**Section 75W Modification Application No. 3 (Major Project MP 10_0105)
44-46 Walker Street, Rhodes**

This letter has been prepared by Urbis Pty Ltd on behalf of Waterpoint Site 1 Lessor Pty Ltd and Waterpoint Site 2 Lessor Pty Ltd in response to the NSW Department of Planning & Infrastructure (DoPI) request for additional information dated 22 October 2013, with regard to MP10_0150 MOD 3 (the Modification).

Area Calculations -
 GFA

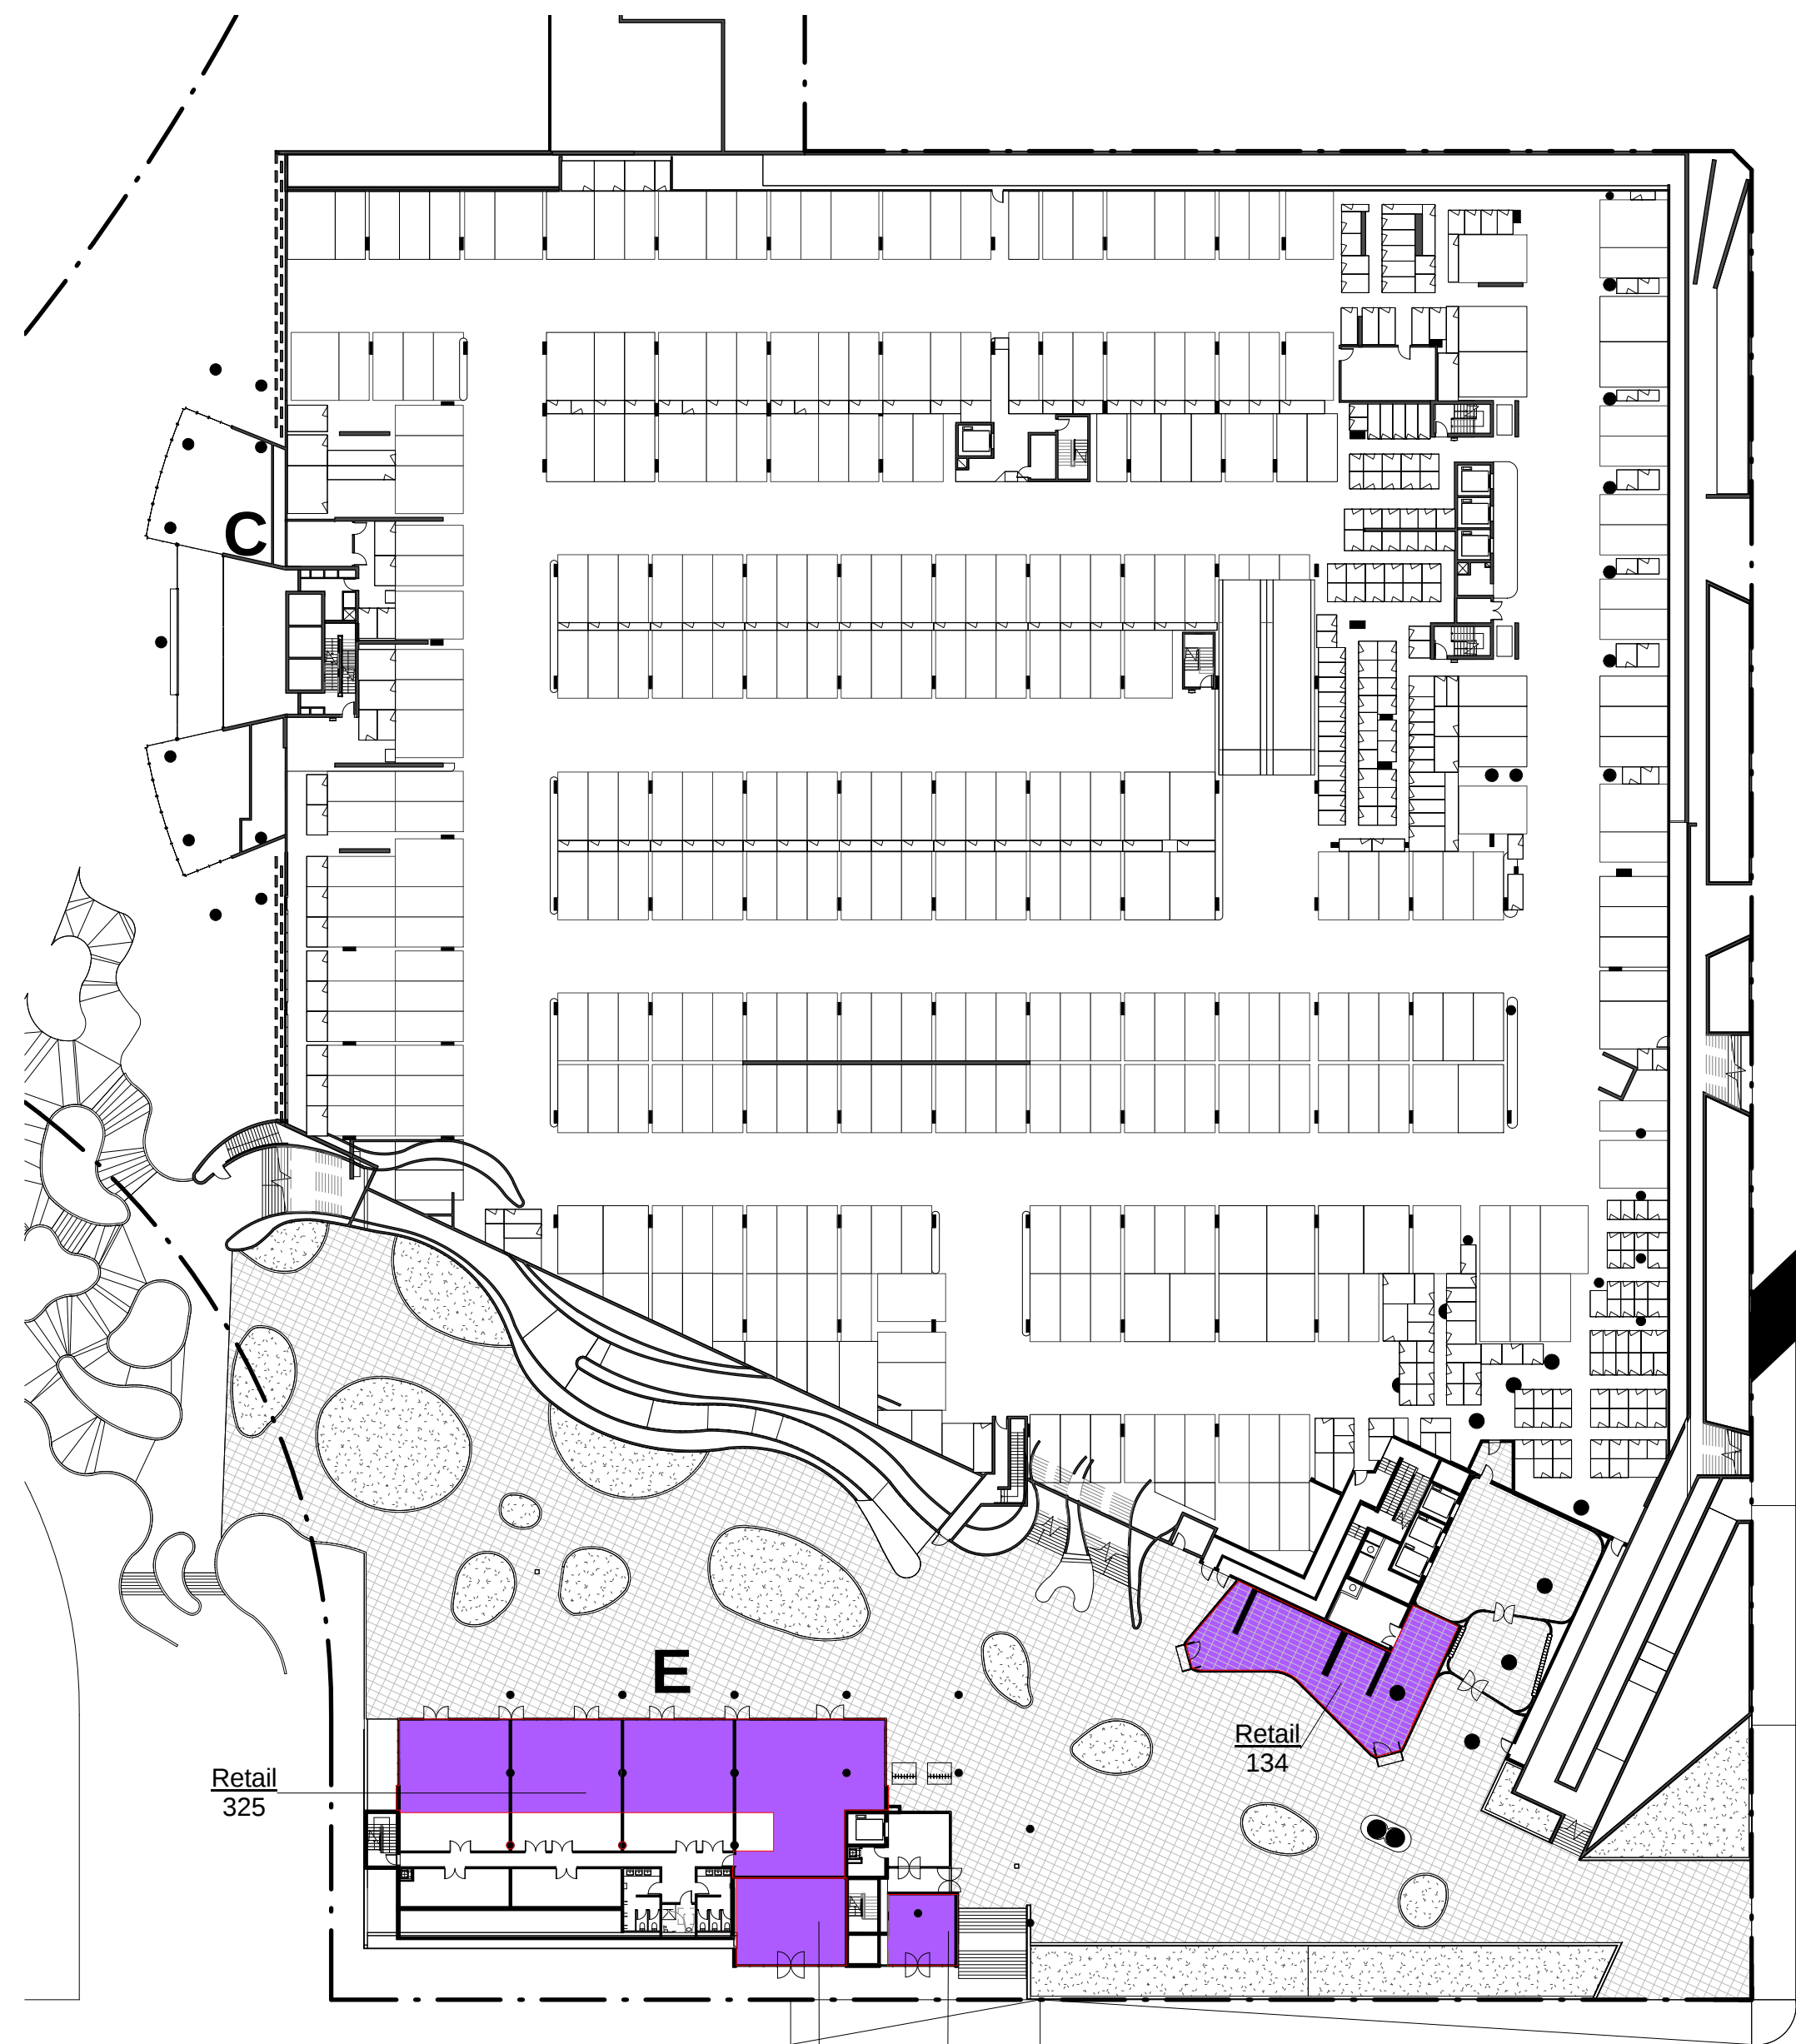
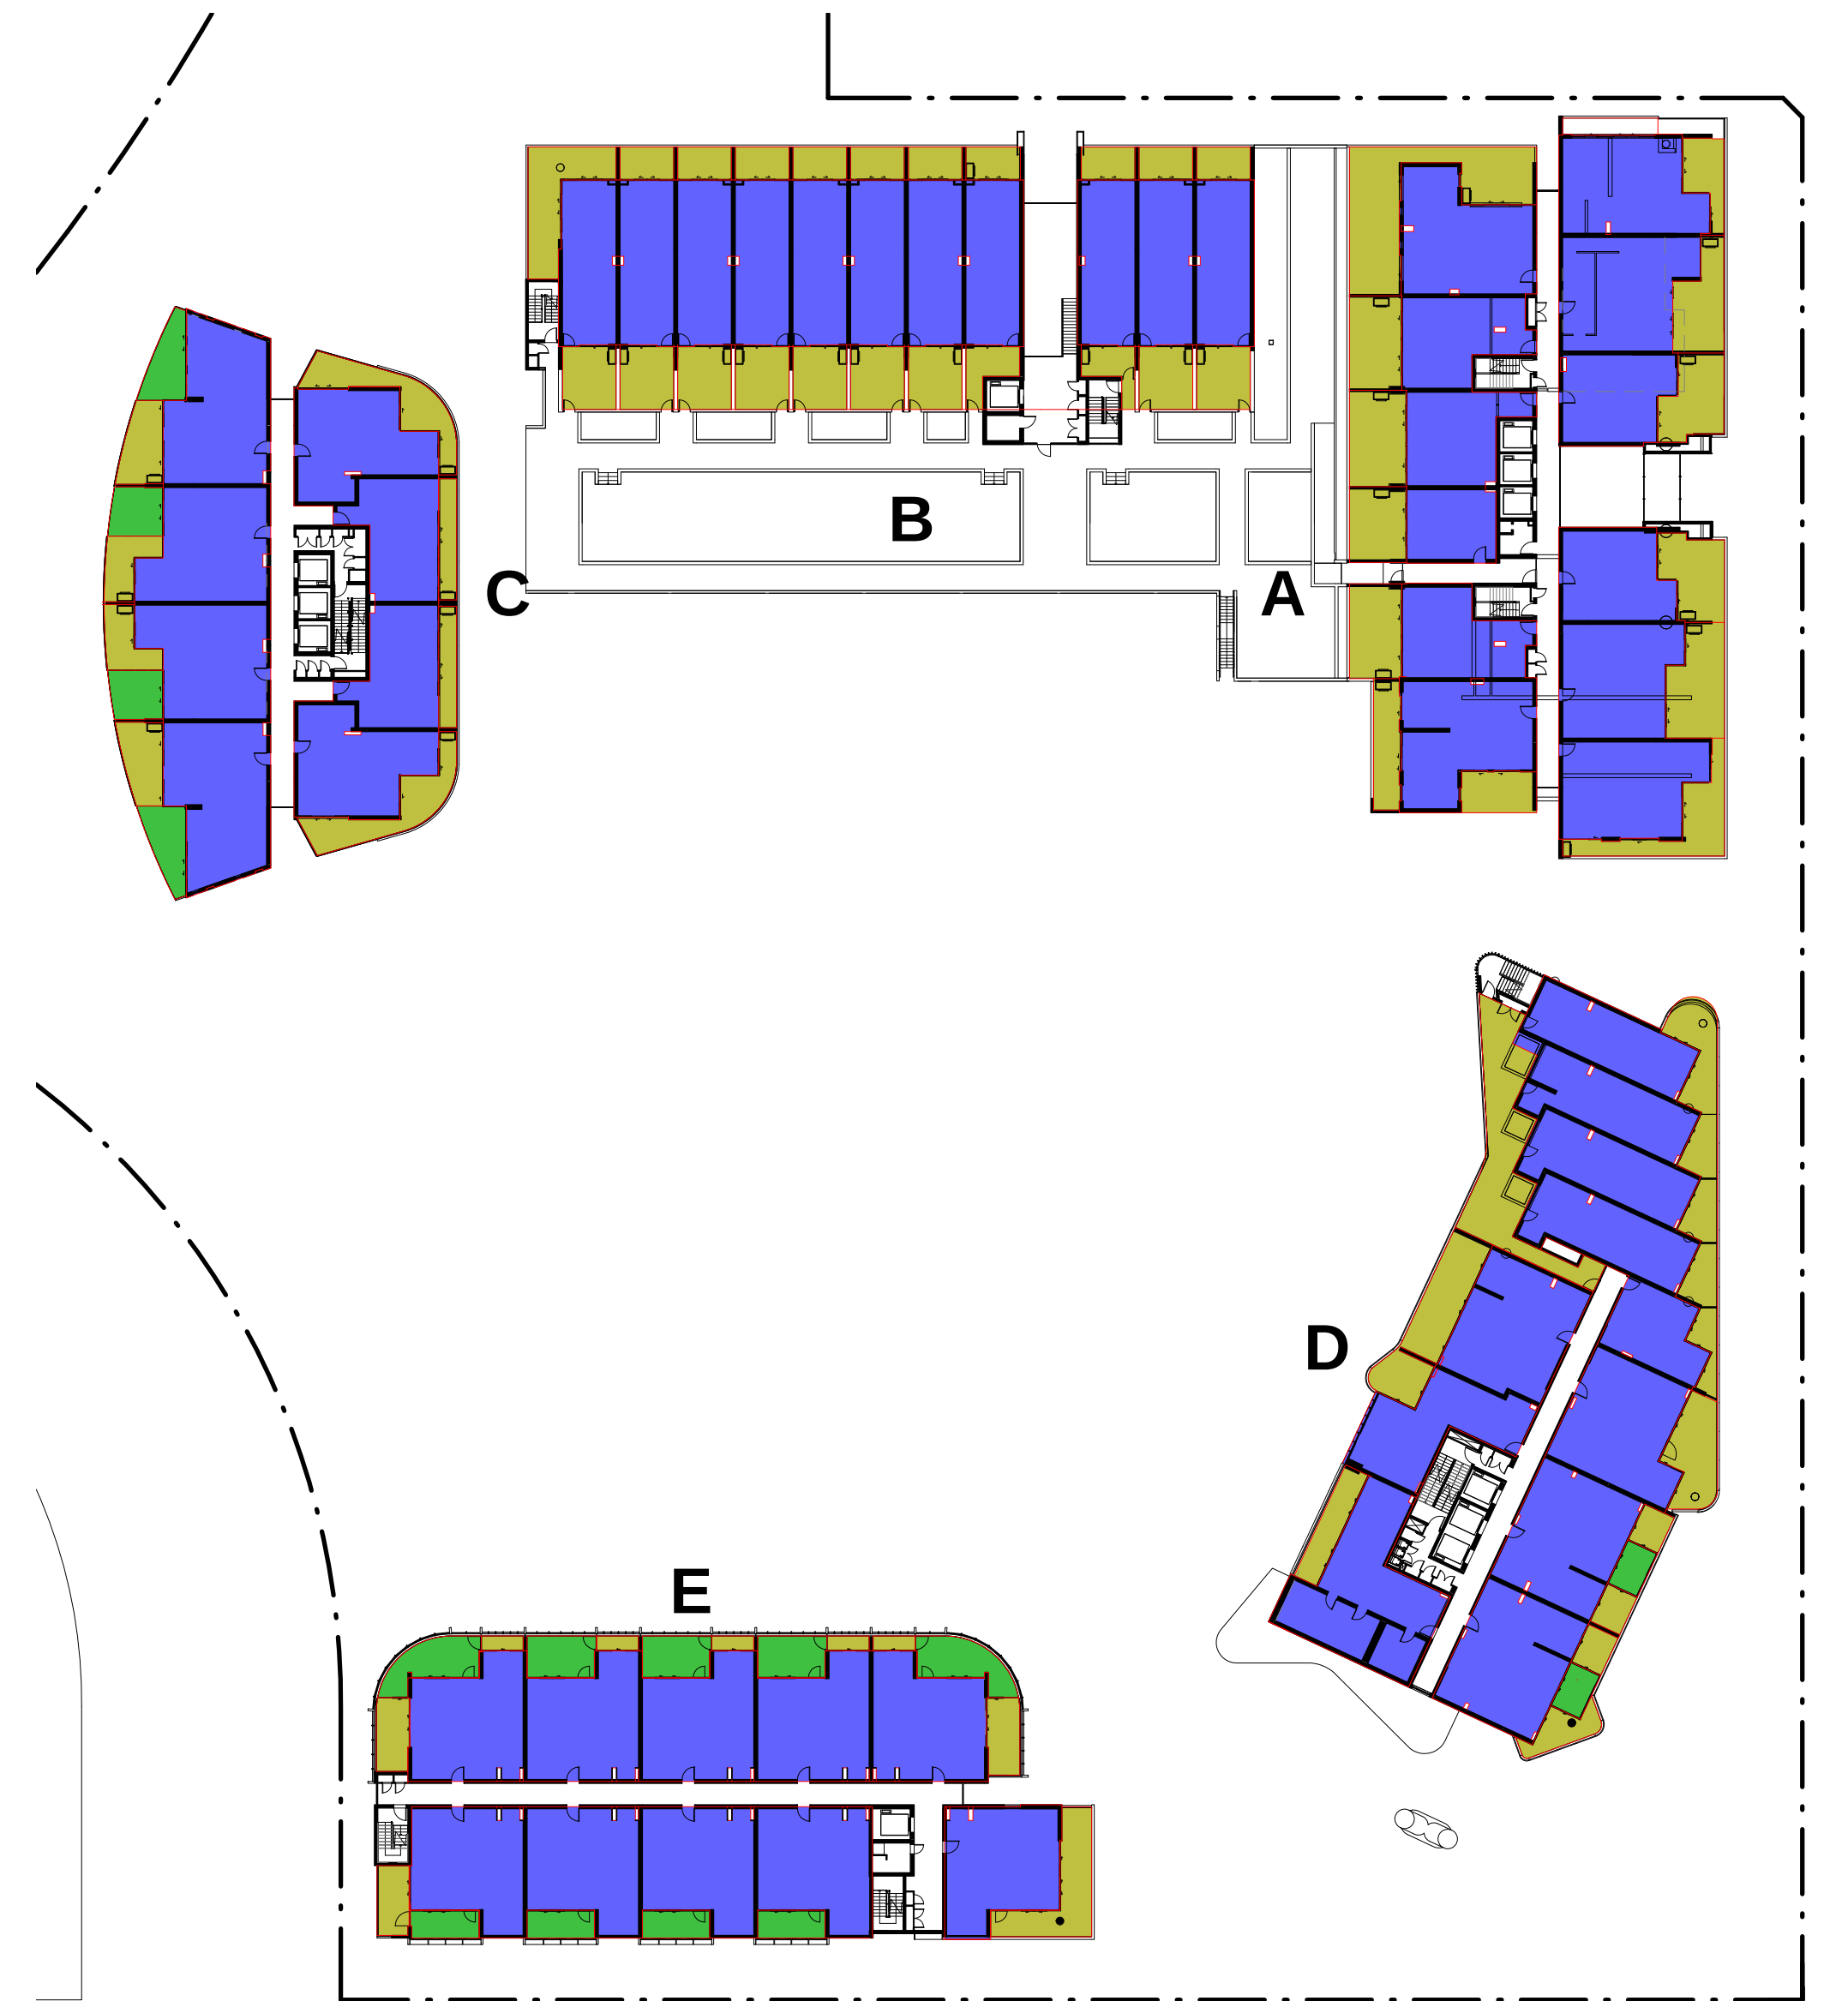
The Department have requested clarification that the definition used to calculate GFA for the proposed modification is the definition contained in Canada Bay Local Environmental Plan 2008 (CBLEP 2008). It is confirmed that the GFA definition for Rhodes West contained at Clause 4.4 (2A) of the CBLEP 2008 has been used to calculate the GFA of the Modification.

Separate calculations of the gross floor area of the development under the following Environmental Planning Instruments have been requested:

As noted above the gross floor area (GFA) has been calculated in accordance with the definition contained in the *Canada Bay Local Environmental Plan 2008* (CBLEP 2008) (Cl. 4.4(2A)). This is the relevant definition as it was the applicable at the time of lodgement of the original Major Project Application MP 10_0105. Subsequent modification applications (MOD 1 & 2) have been assessed and determined by the Planning Assessment Commission with reference to CBLEP 2008.

ITEM	APPROVED	PROPOSED	VARIATION
Total Floor Space	56,513m ²	57,351m ²	+838m ²
Retail Floor Space	1348m ²	1528m ²	+180m ²
Residential Floor Space	55,165m ²	55,823m ²	+658m ²
Wintergardens	2818m ²	4037m ²	+1213m ²
Total Units	743	759	+16
Unit Mix			
▪ 1 bed / studio	306	356	+50
▪ 2 bed	415	387	-28
▪ 3 bed	22	16	-6
Residential Parking	743	759	+16
